FP/70/17/HH

PLAN-017926

Proposal: Single storey side & rear extensions & front porch to existing dwelling.
Site: 45 Westmorland Drive, Felpham, PO22 8NA.
FP/70/17/HH

Proposed Site Layout Plan
(1:500)

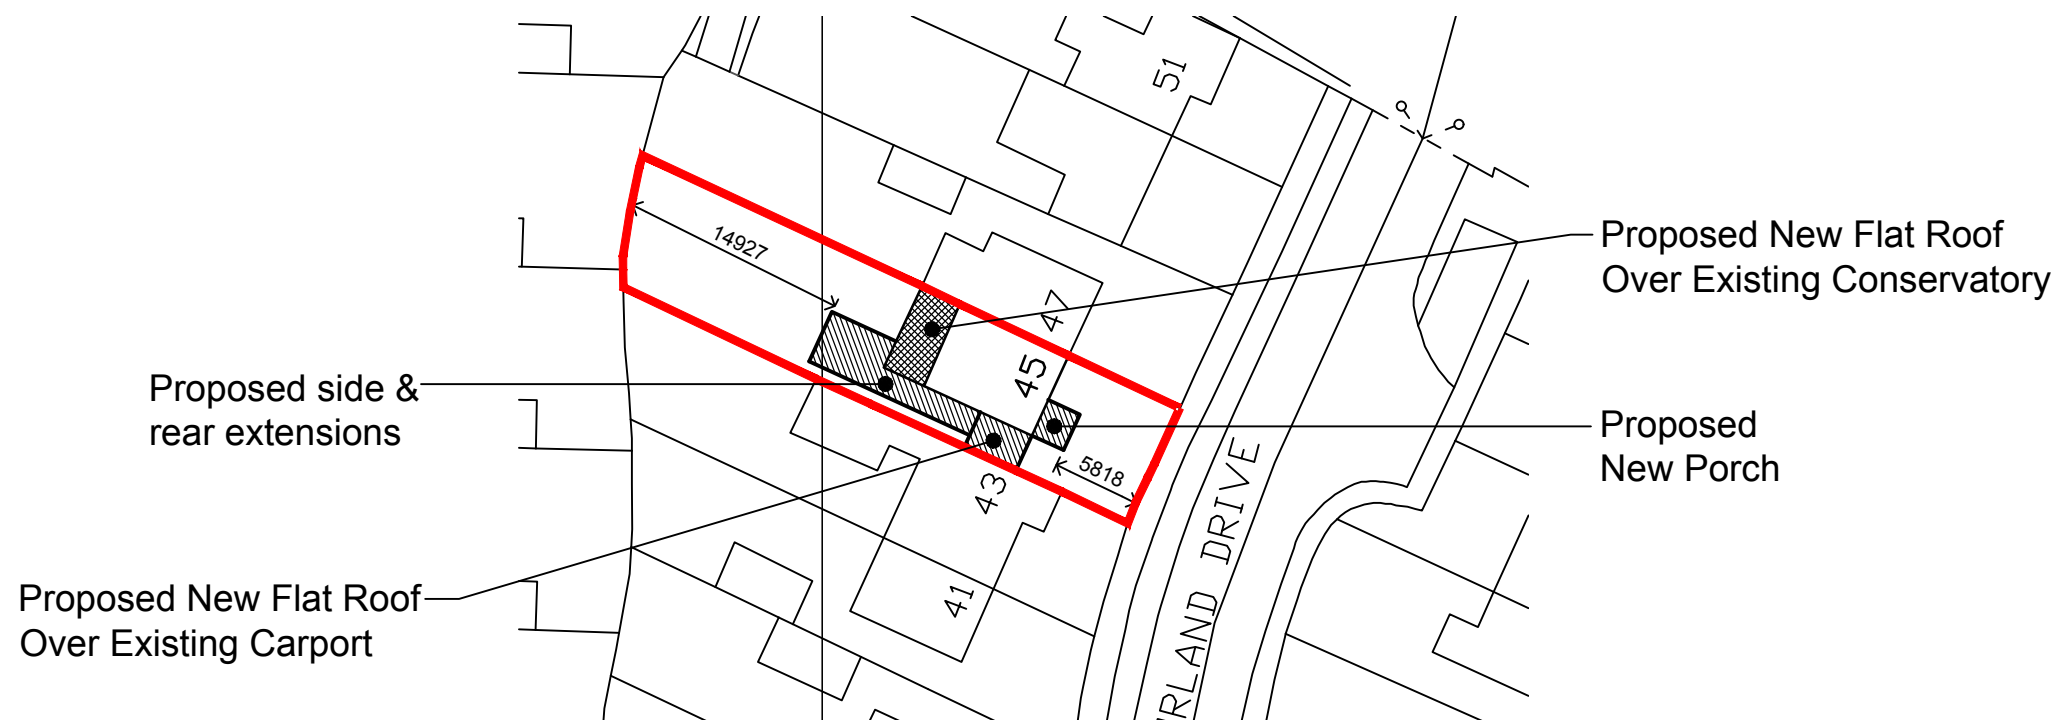
It appears that the developer is intending to build over to a public foul sewer which is crossing the site. Building over a "public sewer" is not normally permitted by Southern Water. However, under certain circumstances building over a sewer may be allowed. The conditions associated with the buildover/close to a sewer are contained in Southern Water guidance notes which are available at: www.southernwater.co.uk. A formal application to build close to the sewer will required to be submitted by the applicant.
